Our Ref: EN010115

Date: 22 April 2024

Application by Five Estuaries Offshore Wind Farm Ltd for an Order Granting Development Consent for the Five Estuaries Offshore Windfarm

Advice following issue of decision to accept the application for examination

**DRAWING NUMBER:** 005023883-01  
 APFP Regulation: 5(2)(m)  
 Sheet No: 3 of 20  
 SCALE: 1:2,500 PLOT SIZE: A1 DATUM: OSGB 1936 PROJECTION: BNG

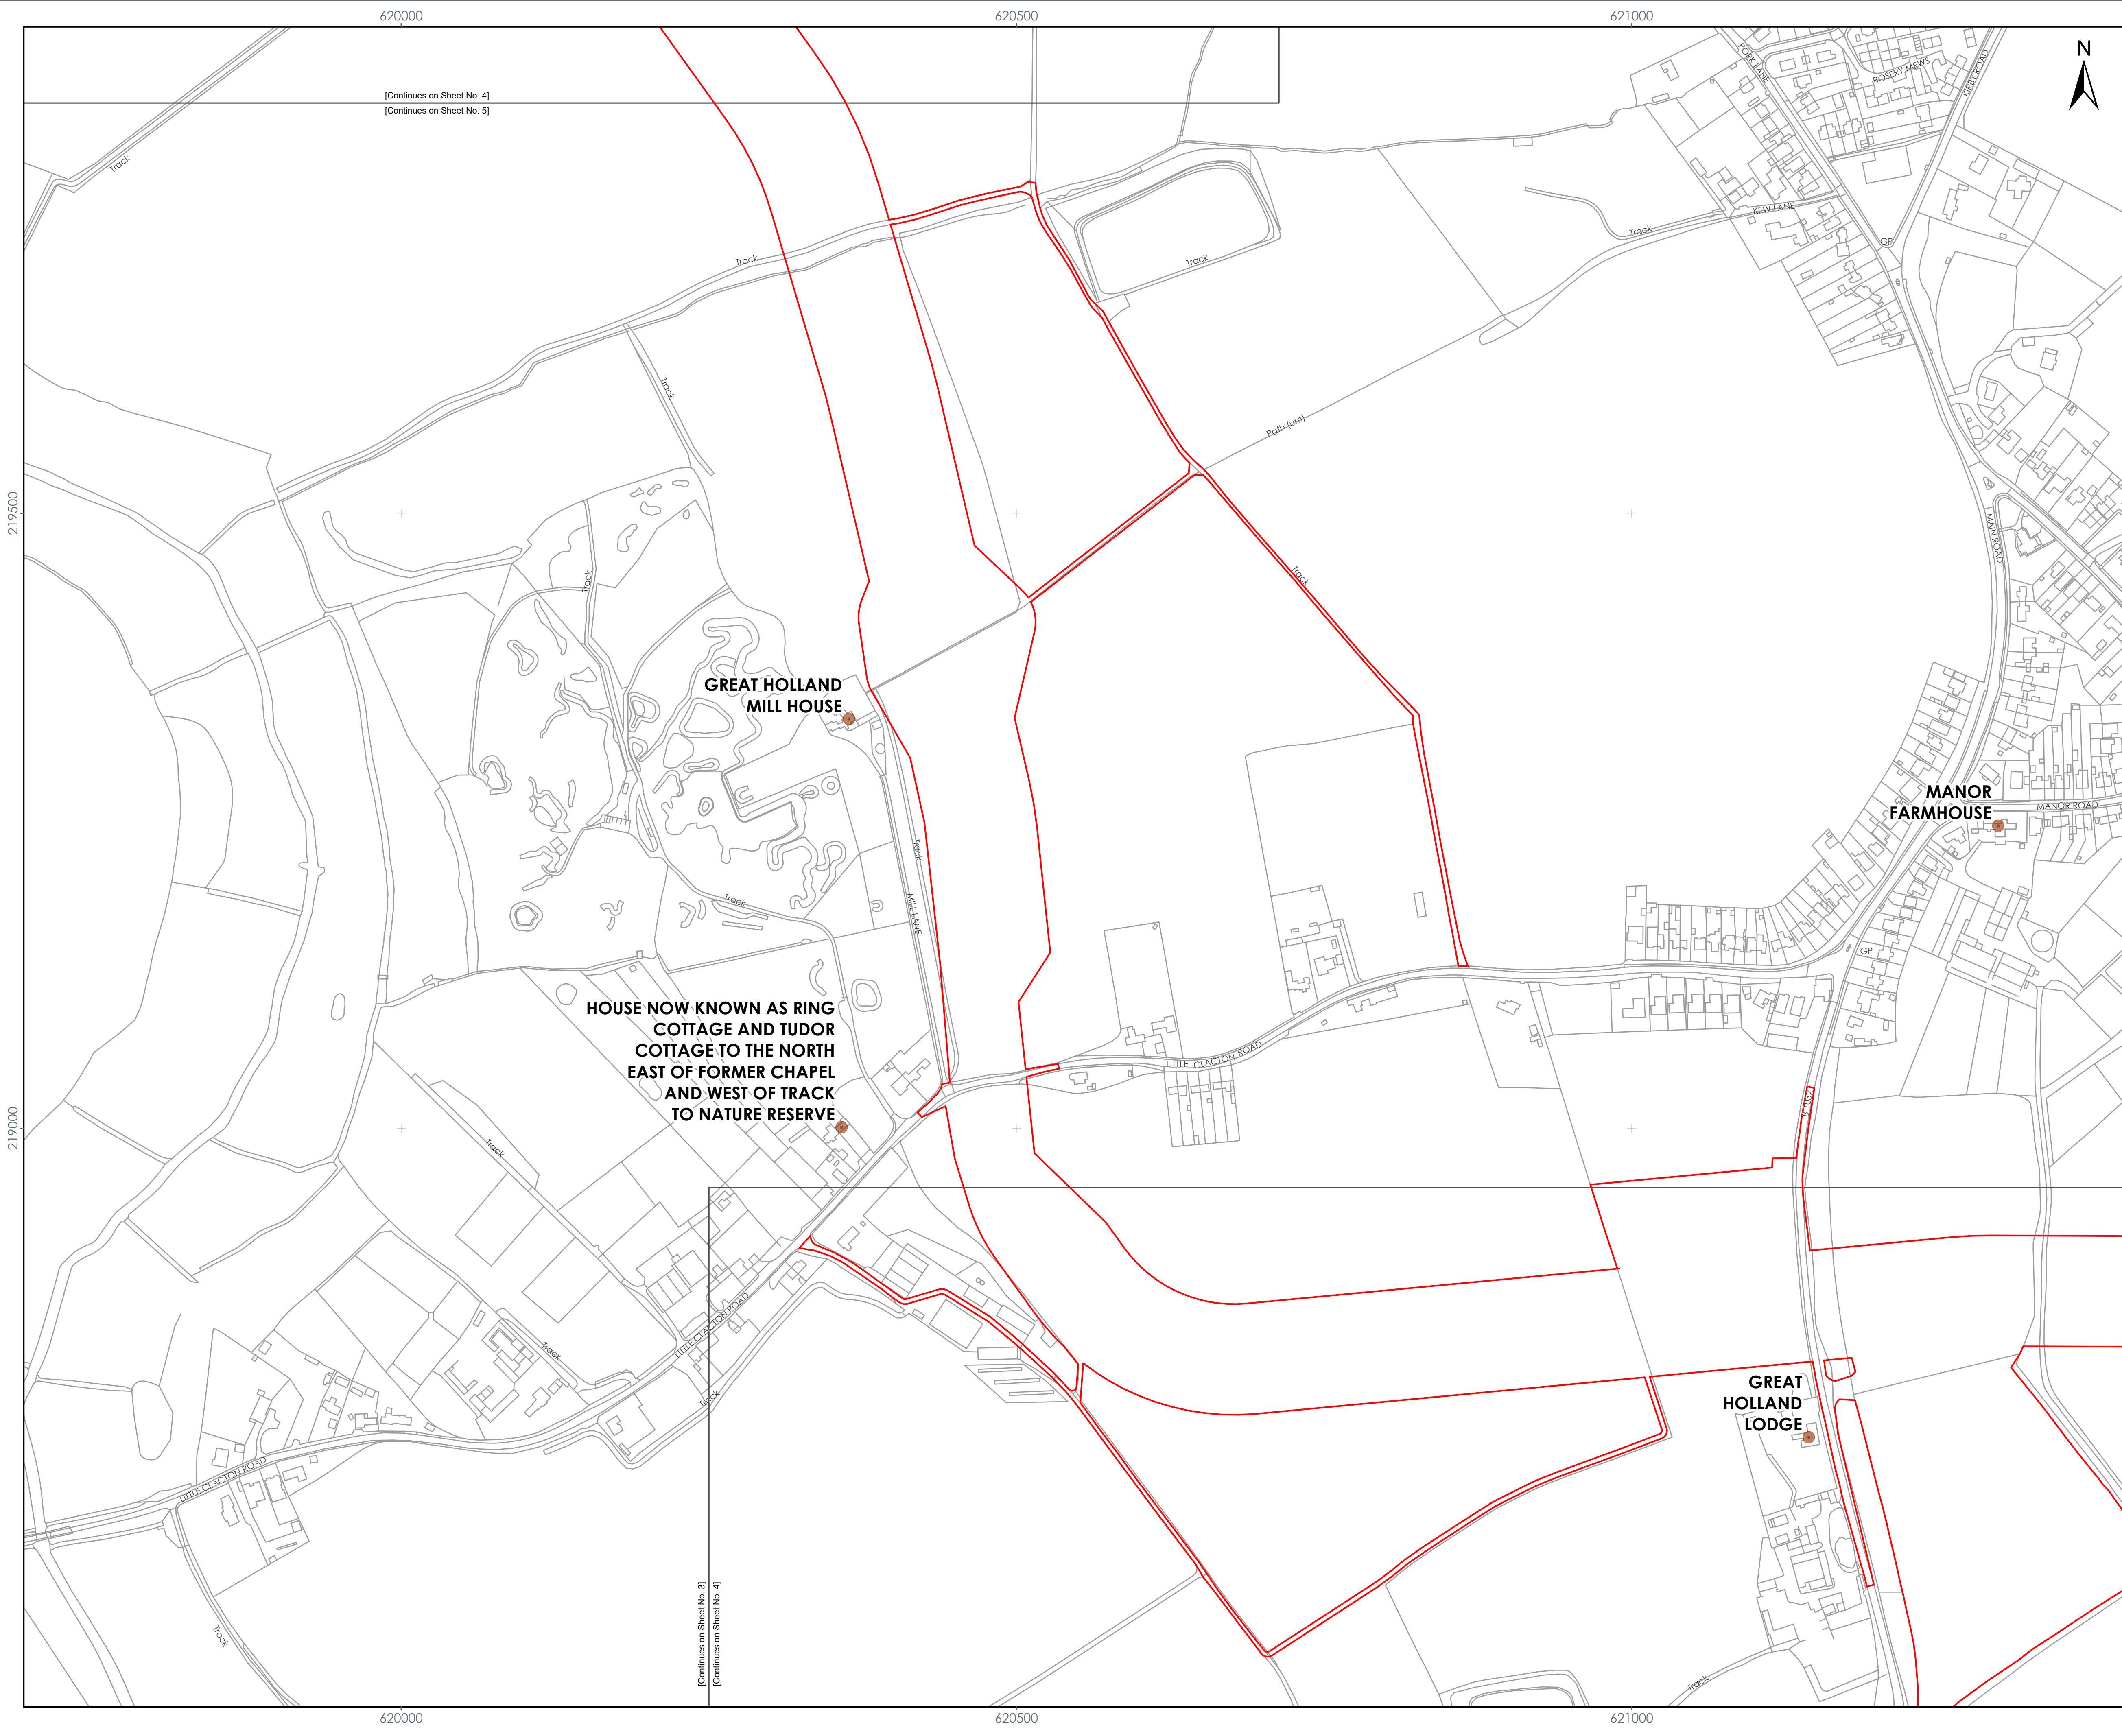
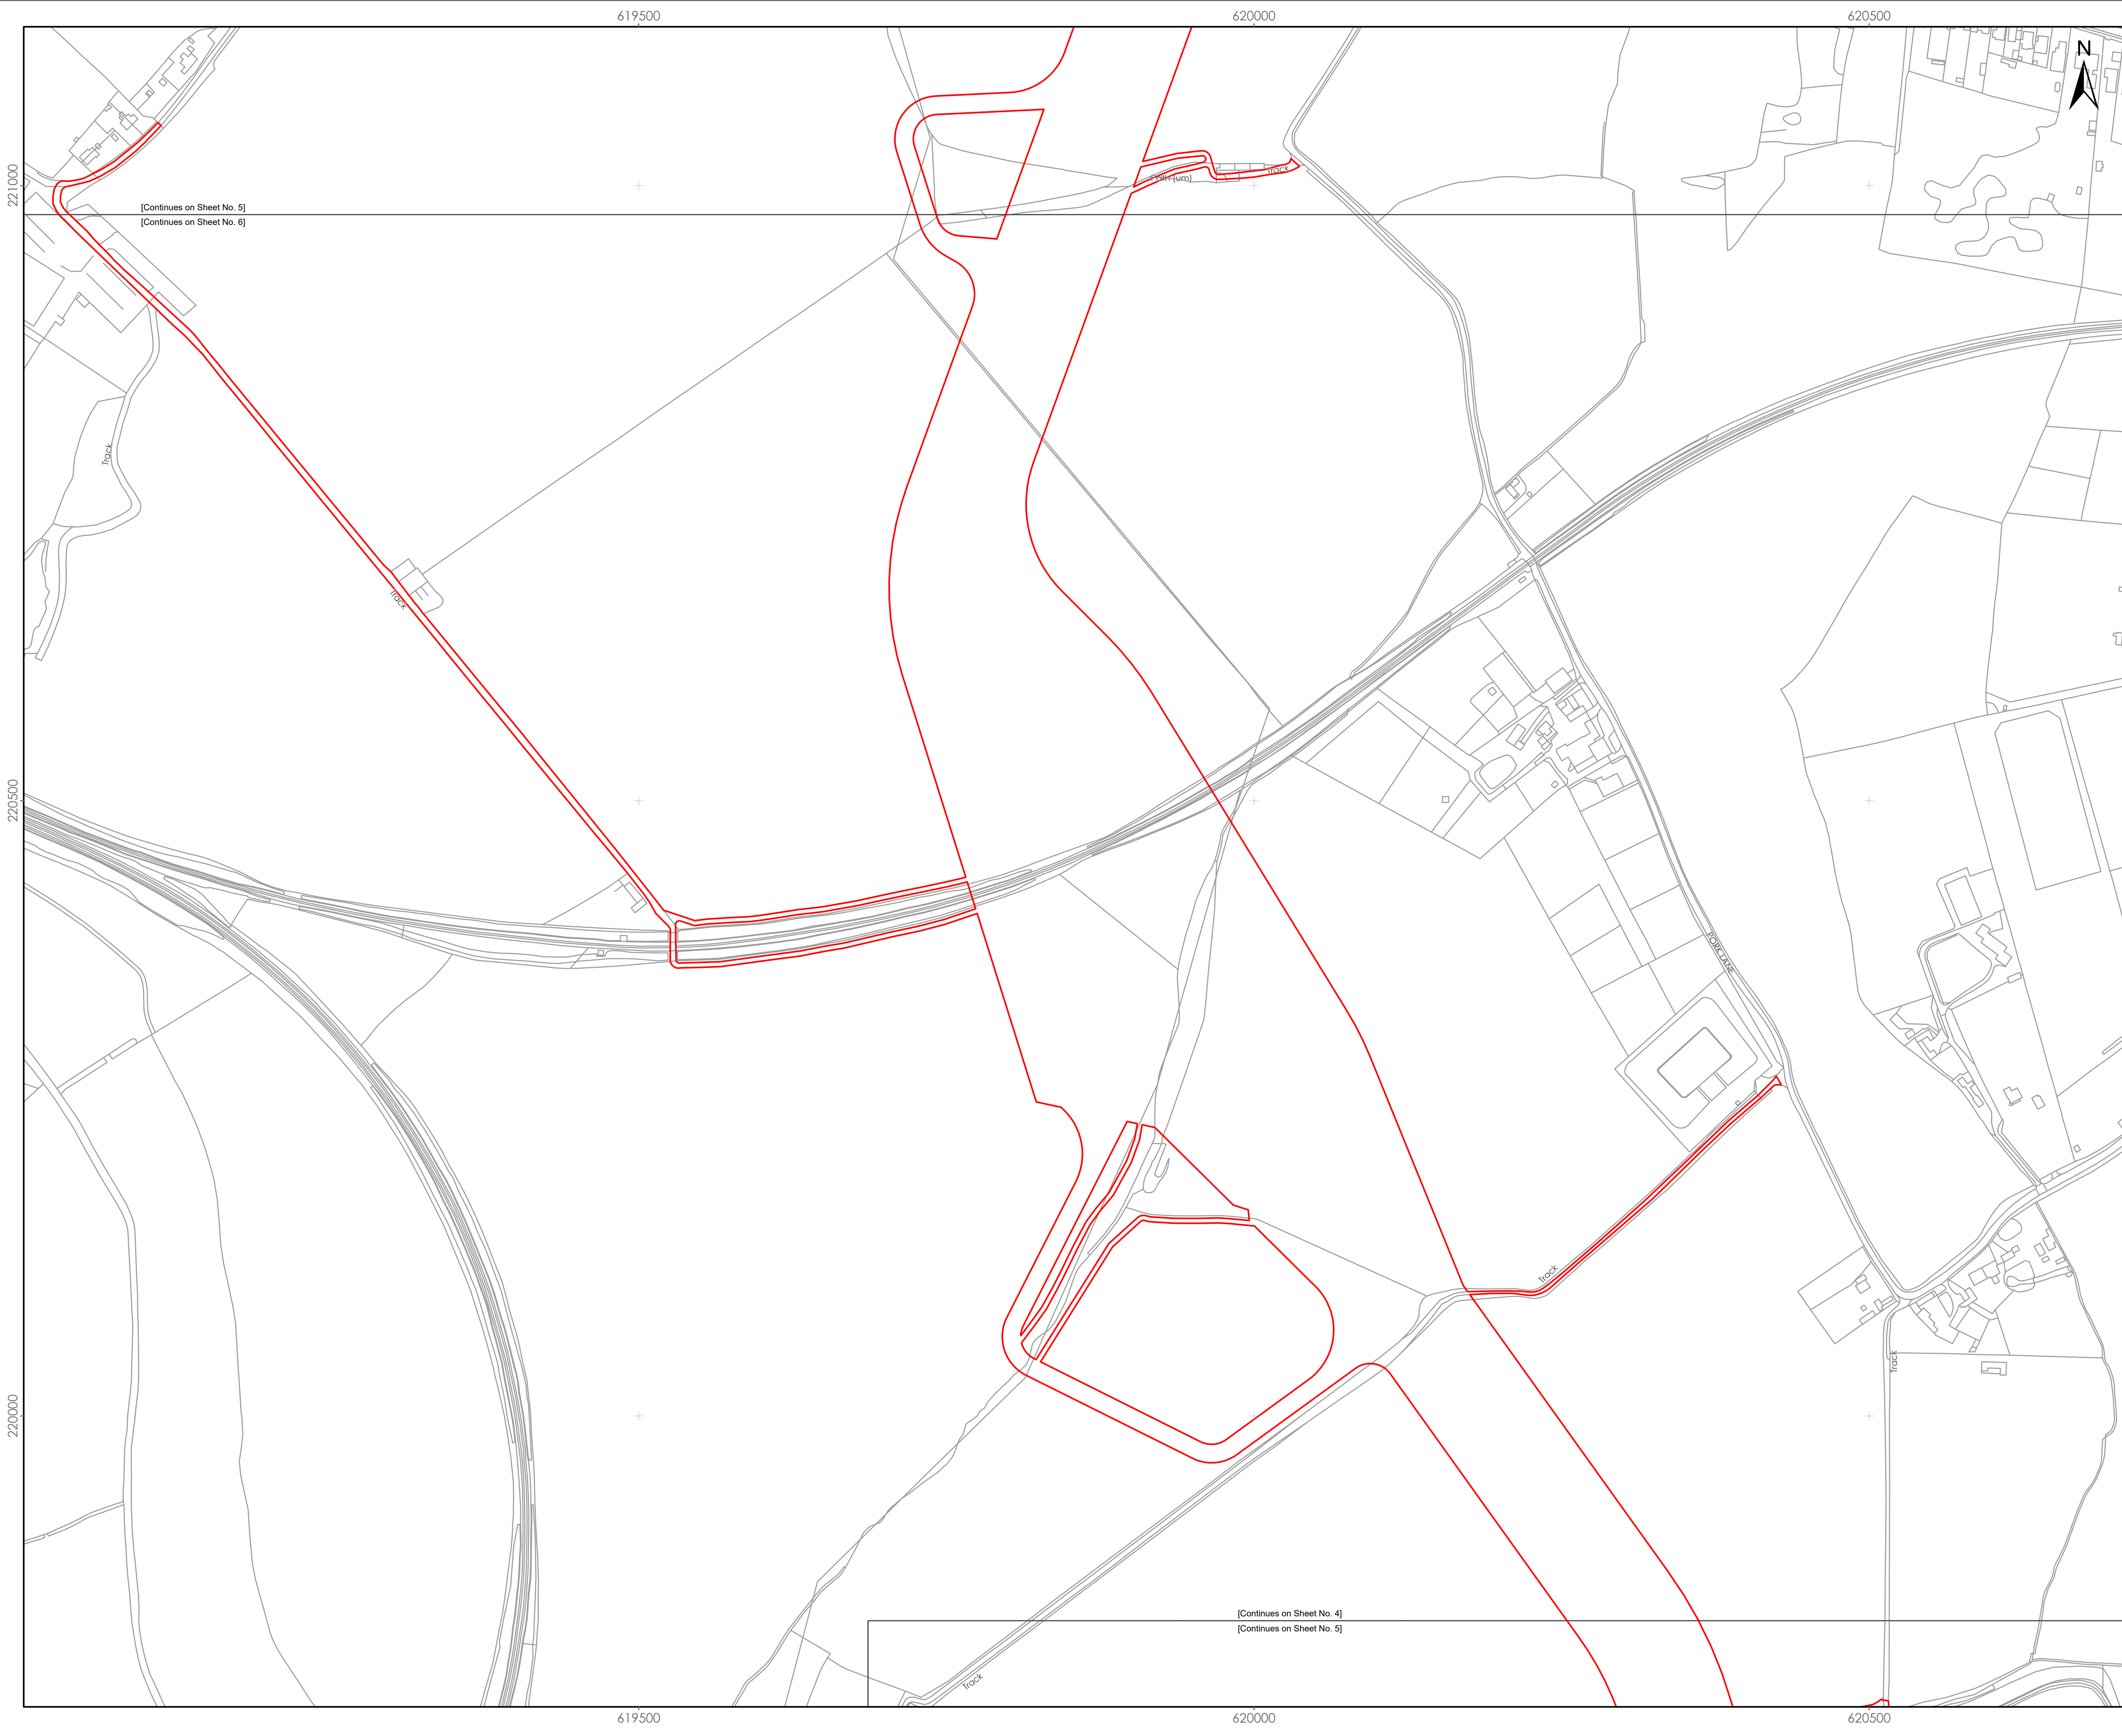
Historic environment plans show a woodland layer on the key, but this is not visible on the plans.

These plans also show ancient woodland which may not be required in the historic environment context and could be included in the **Statutory or Non-Statutory Sites and Features of Nature Conservation - Onshore plans (Doc 2.13)**.
